Appeal Decisions

Appeal A Ref: APP/R4408/F/22/3292758

Land at 3 Fieldhead Manor, The Granary, Elmhirst Lane, Dodworth, Barnsley S75 4LD

- The appeal is made under section 78 of the Town and Country Planning Act 1990 against a refusal to grant planning permission.
 - The appeal is made by Mrs I Wainwright against the decision of Barnsley Metropolitan Borough Council.
 - The application Ref 2021/1244, dated 13 September 2021, was refused by a notice dated 25 November 2021.
 - The development proposed is replacement garage doors.
-

PROPOSED FRONT / SIDE ELEVATION GARAGE DOOR

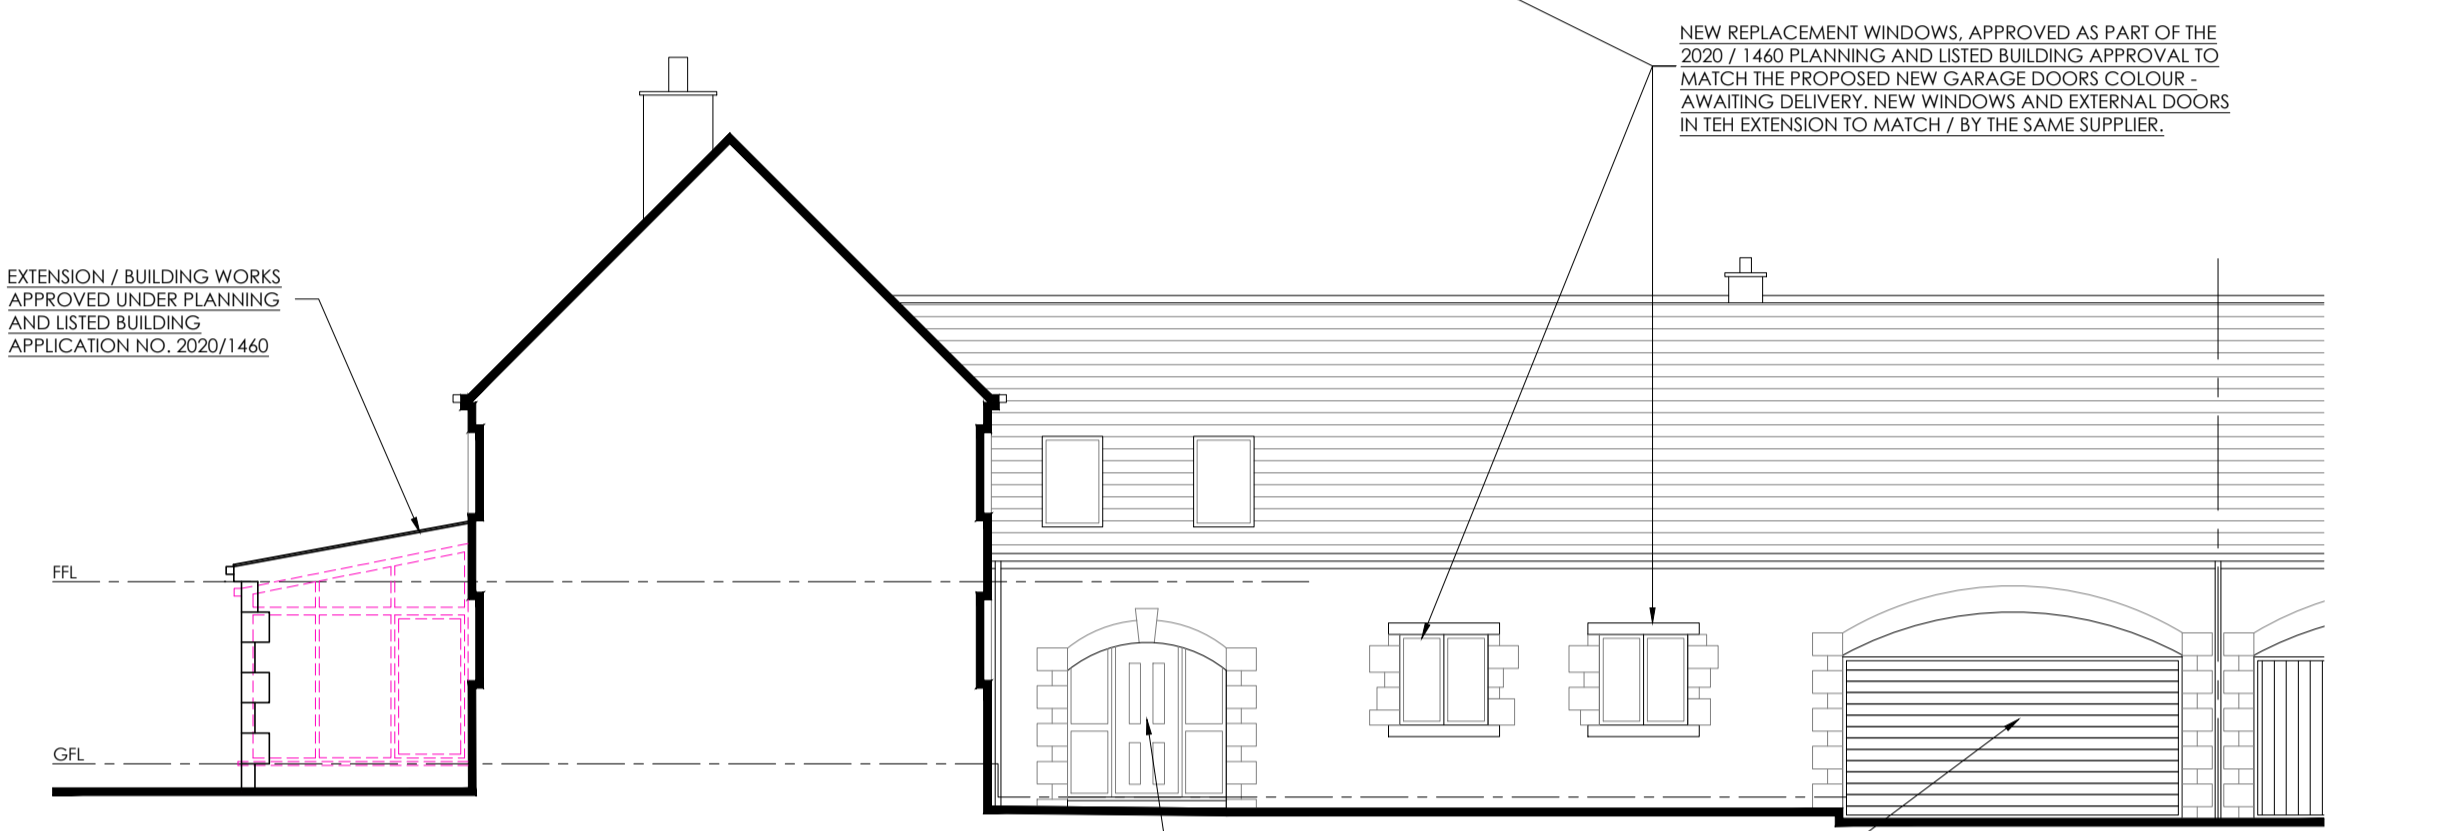
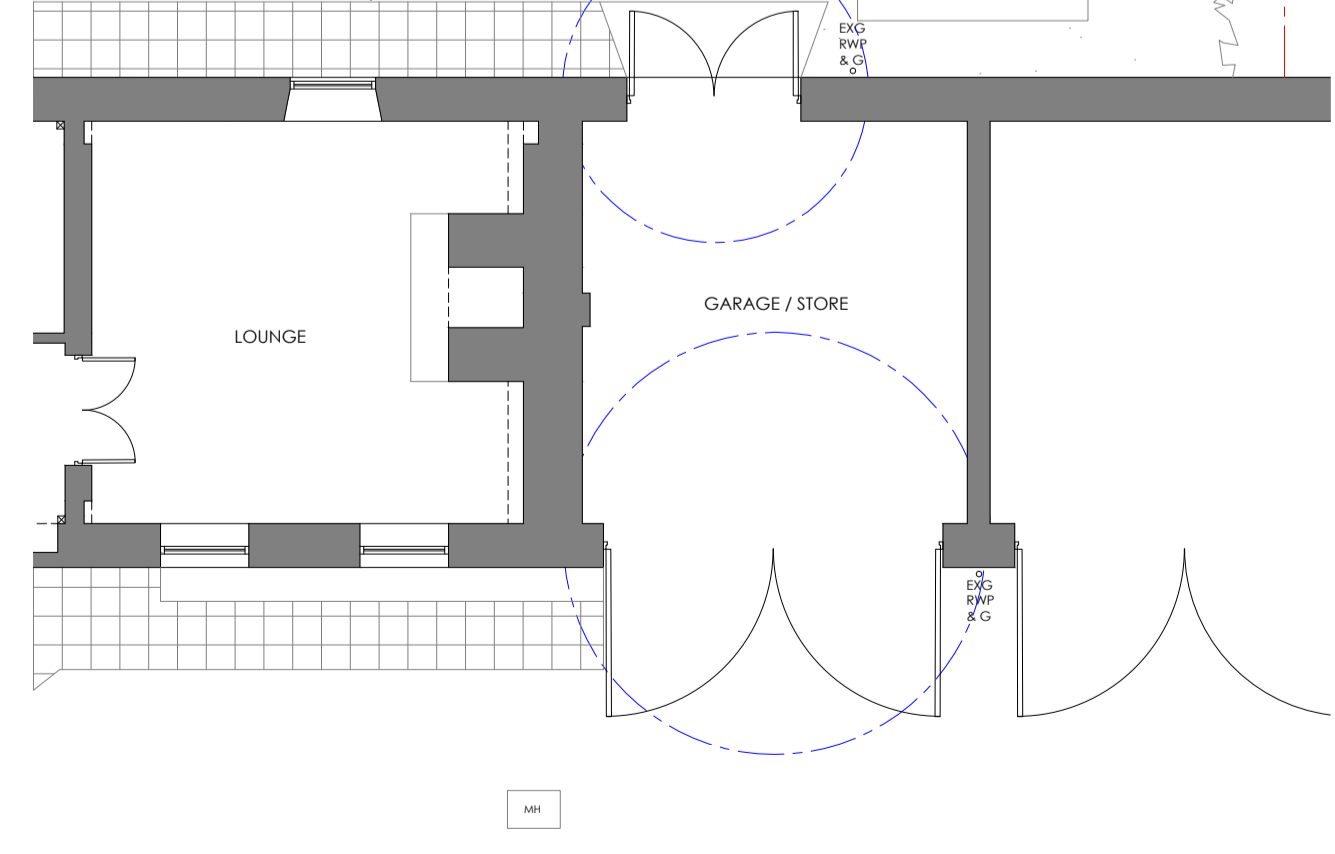
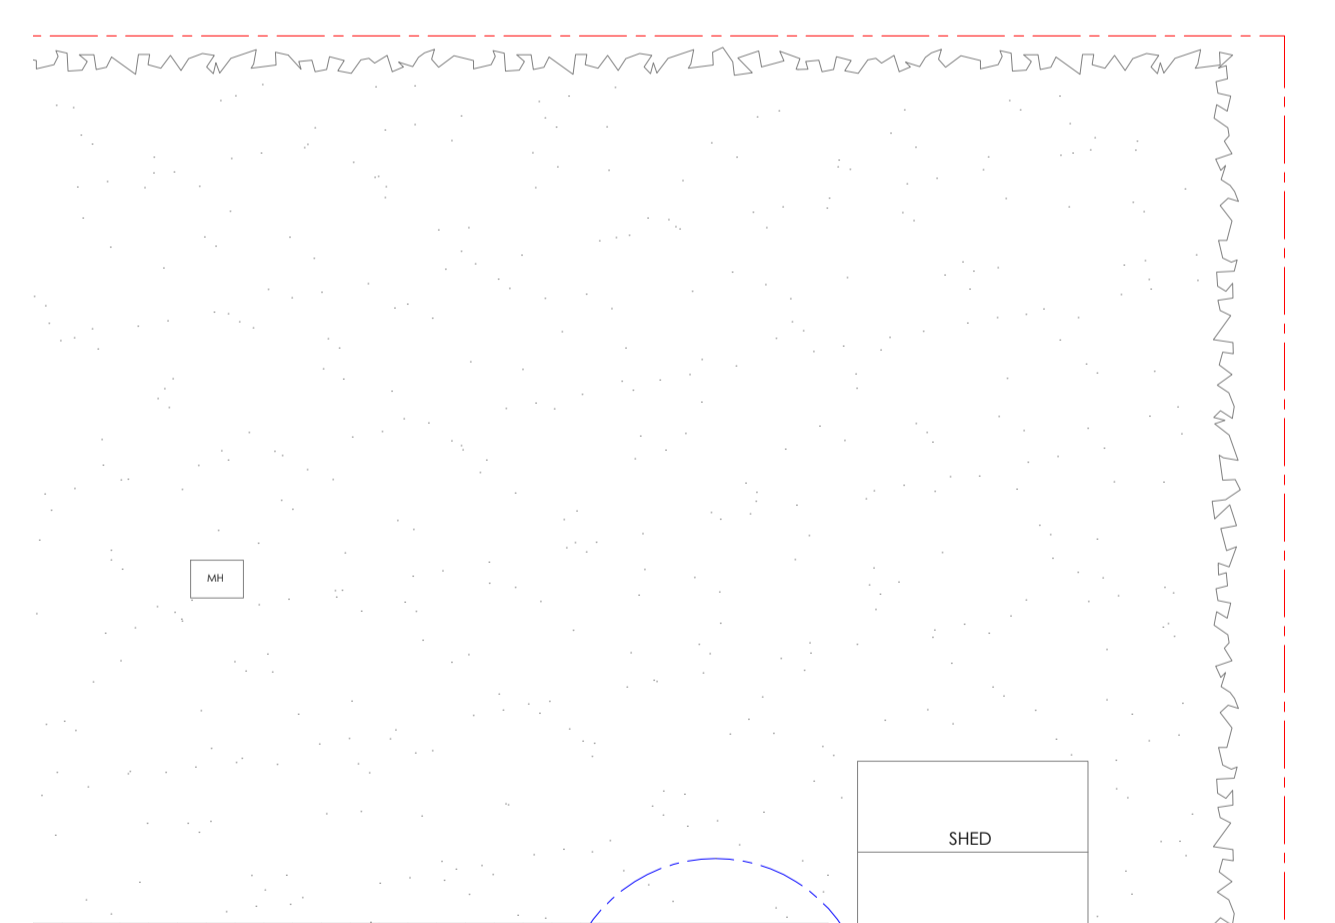
8. The works to the building are the replacement of vertical boarded timber garage doors which, from the evidence before me, had a painted/stain finish. The replacement doors are metal roller shutters finished in grey.

9. The garage doors which have been replaced reflected the building's vernacular in their materials and visual arrangement. Furthermore, the double door matched the garage doors at No 2 Fieldhead Manor and there was a visual harmony in the appearance of the property and the adjoining buildings known as Nos. 2, 4 and 5 Fieldhead Manor. The unauthorised doors by reason of their materials and design contrast sharply with the historic character and aesthetic vernacular of the listed building. They have a crude and incongruous appearance and fail to preserve the special architectural and historic interest of the building.

- The requirements of the notice are:
 - (i) Return the garage doors (as specified in paragraph 3) at the Land to their original condition, prior to the breach of Listed Building Control taking place (referenced in Appendix 5).

- (ii) Ensure that said doors cited in paragraph 3 match those of the adjacent property; 2 Fieldhead Manor, Elmhirst lane, Silkstone, Barnsley, S75 4LD.
